Charlotte Department of Transportation

Memorandum

Subject: Rezoning Petition 08-073: Located on both sides of Statesville Avenue
between Newland Road and Woodward
Avenue (revised 5/13/08)

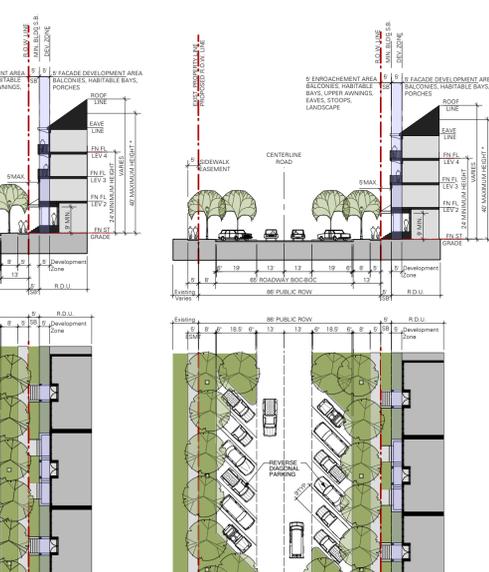
1. Street cross section 3 on Sheet SP 104 is based on the USDG Residential-Medium street design. It anticipates on-street parking for single family homes with driveways. Driveways help to break up the available street parking to allow two-way traffic operation even though the travel lanes may be reduced to a single lane at some locations. The site plan indicates that single family detached and attached will be developed along this street cross section. If there are no driveways or few driveways, on-street parking may need to be prohibited on one or both sides of the street unless the Residential –Wide cross section is used (3MU).
2. Additional comments and any required transportation improvements will follow our review of the TIS. We are completing our review of the draft TIS and will send our comments to the petitioner the week of June 2nd.
